Project Name and Address
Diane Gilstrap
 Site Plan
 13285 Ravine Drive West
 El Paso County, Colorado
 (719) 675-7308
 lizadiane64@gmail.com

V2 - Site Plan - RLR.pdf Markup Summary

Project: 24-0185	Project Name and Address
Date: 19 Feb 2025	<b>Diane Gilstrap</b>
Drawn by: cem	Site Plan 13285 Ravine Drive West El Paso County, Colorado (719)675-7308 lizadiane64@gmail.com
Checked by: cem

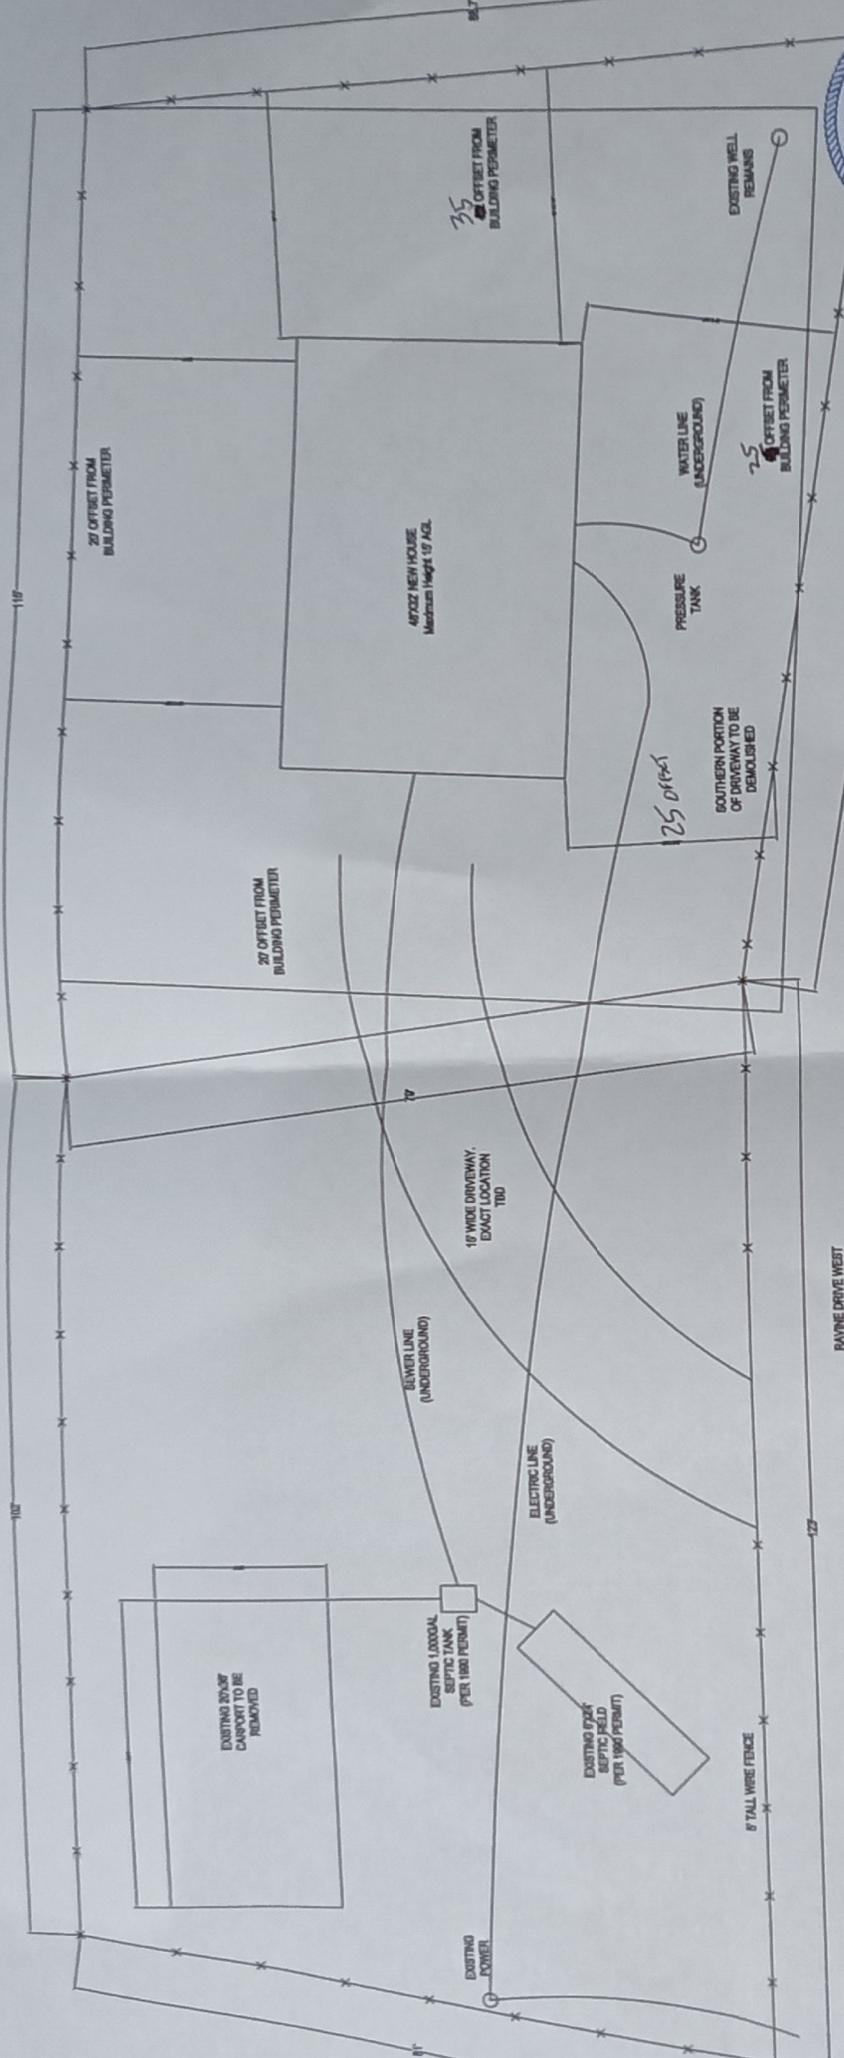
This equals 4.1 acres. please change this to 0.41 acres

Show setbacks from the closest point of the house to the front property line
